**Highways England: A303 Amesbury to Berwick Down
Project, Development Consent Order Application**

Scheme Reference: TR010025

Written Representation on

Biodiversity, Biological Environment and Ecology

PROPOSED BORED TUNNEL - (WORK No. 1F)

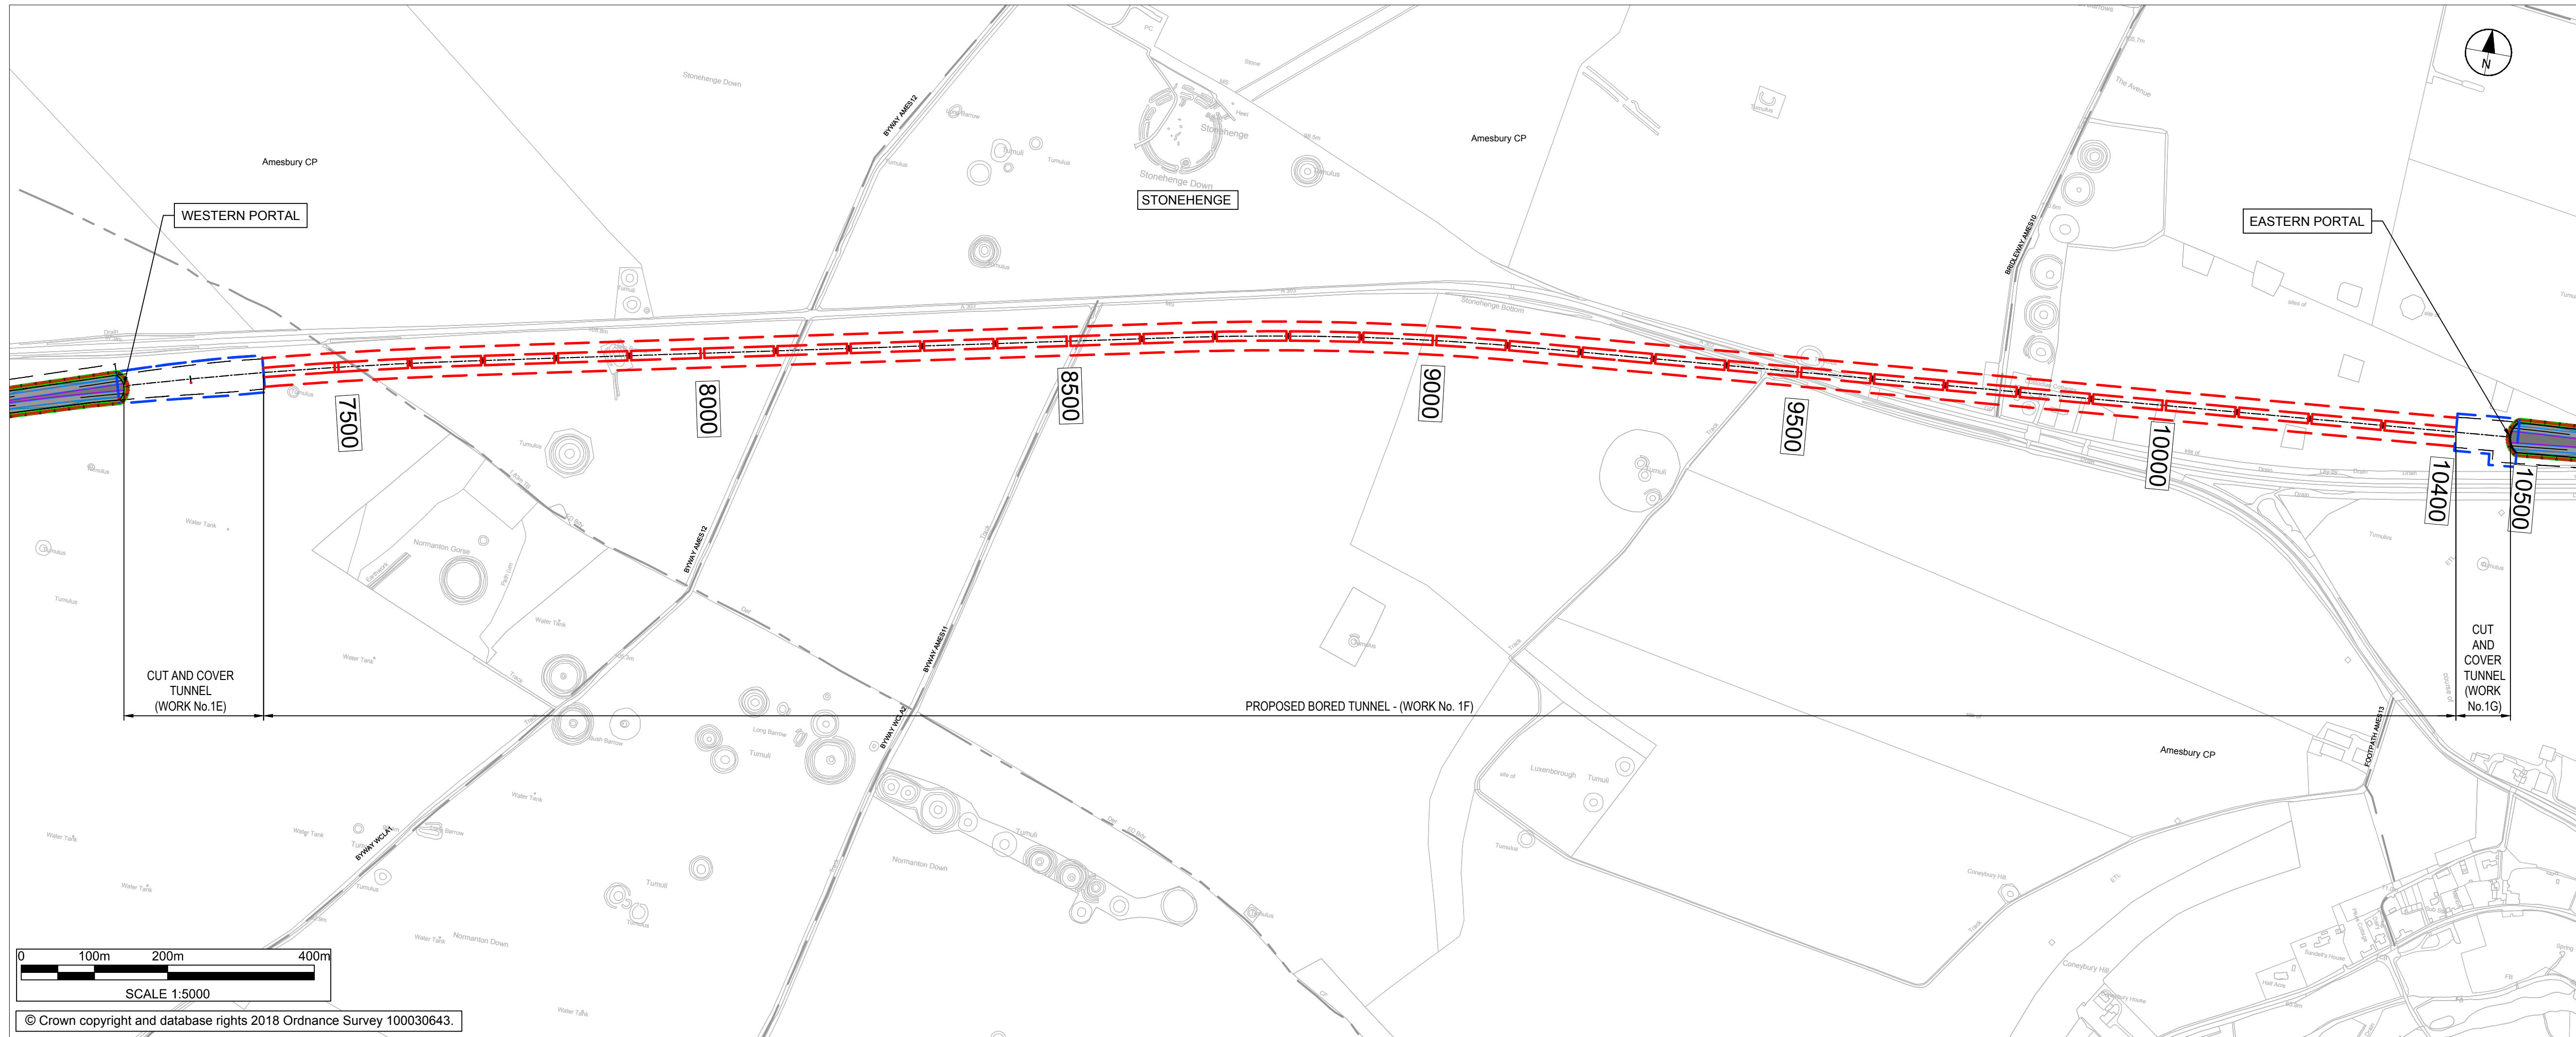
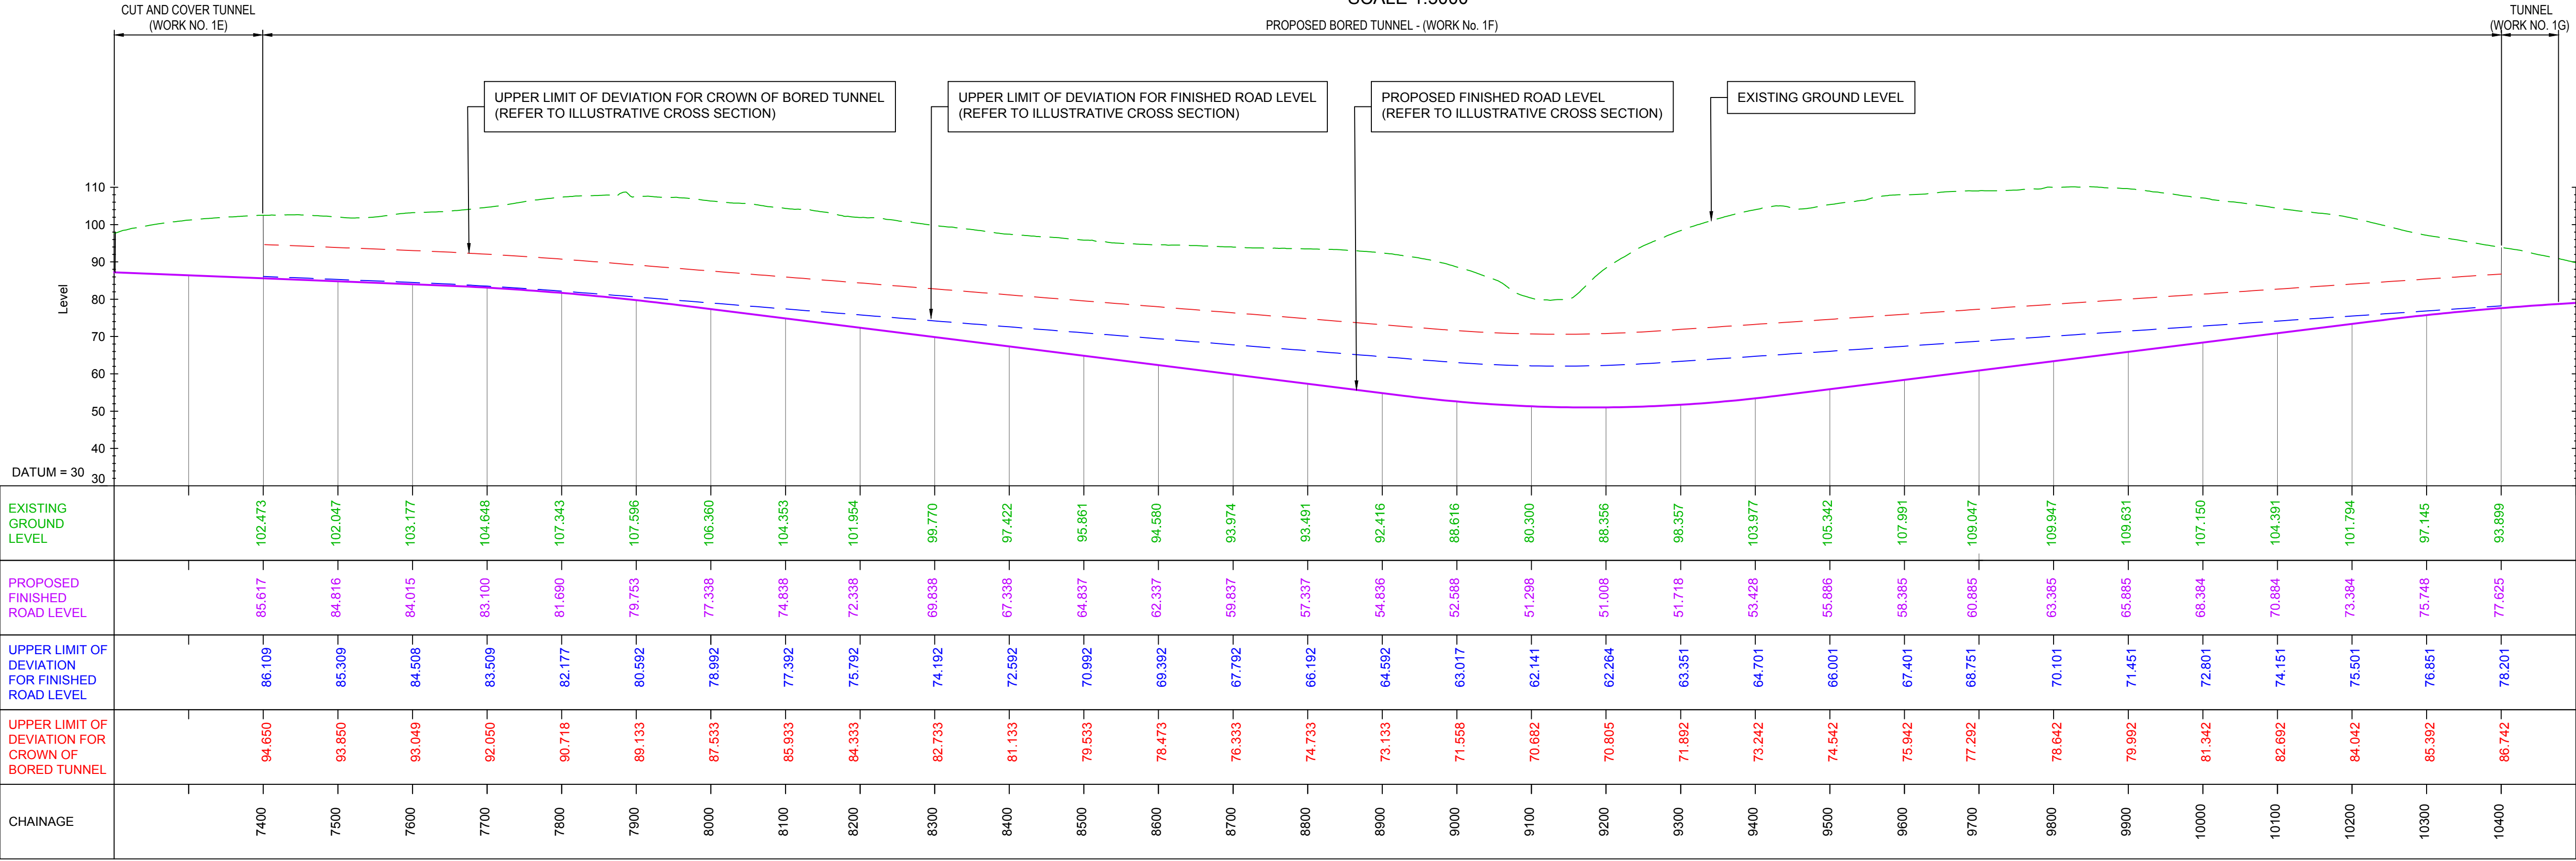
1.4. Of particular concern to us, however, and not mentioned by Highways England in its Statement to Inform the Appropriate Assessment, are the impacts on the Chalk Aquifer and consequently the River Avon SAC that could arise from construction of the proposed tunnel. It is understood that a tunnel boring machine (TBM) would be employed for the work, requiring the use of a bentonite shield-based TBM. We have received specialist geotechnical and hydrogeological advice from Dr George M. Reeves, CGeol., CEnv., PhD., MSc., BSc. (Hons), FGS, FIMMM, that:

“ . . . the impacts of constructing the twin bores of the tunnel using these methods through heavily fractured Chalk (with RQDs [Rock Quality Designations] of 20 or less), will profoundly and adversely affect the Chalk Aquifer, both along the tunnel route, and to the western and eastern areas of the line of the proposed project.

This method of tunneling, with associated ground stabilization by grout, will create a “groundwater dam”, or significant barrier to the current movement of groundwater,

The necessity to use a bentonite shield system (“slurry”) grout to stabilize the ground ahead of and around the tunnel boring is therefore likely to lead to significant groundwater contamination affecting groundwater quality in the area where the current natural groundwater flow and quality conditions will be affected.

This will be especially significant in the western section of the proposed tunnel, (and consequently further westwards along the proposed scheme) where, in the published Highways England site investigation data, highly phosphatic-rich Chalk has been identified as extensive, both for the original 2004 project (Mortimore et al., 2017)³ and in more recent boreholes drilled for the present scheme.

Therefore the tunnel itself would profoundly affect the movement of groundwater southwards towards the River Avon to the east and will also affect groundwater movement to the west. Derogation of current groundwater chemistry and hence water quality will undoubtedly result.
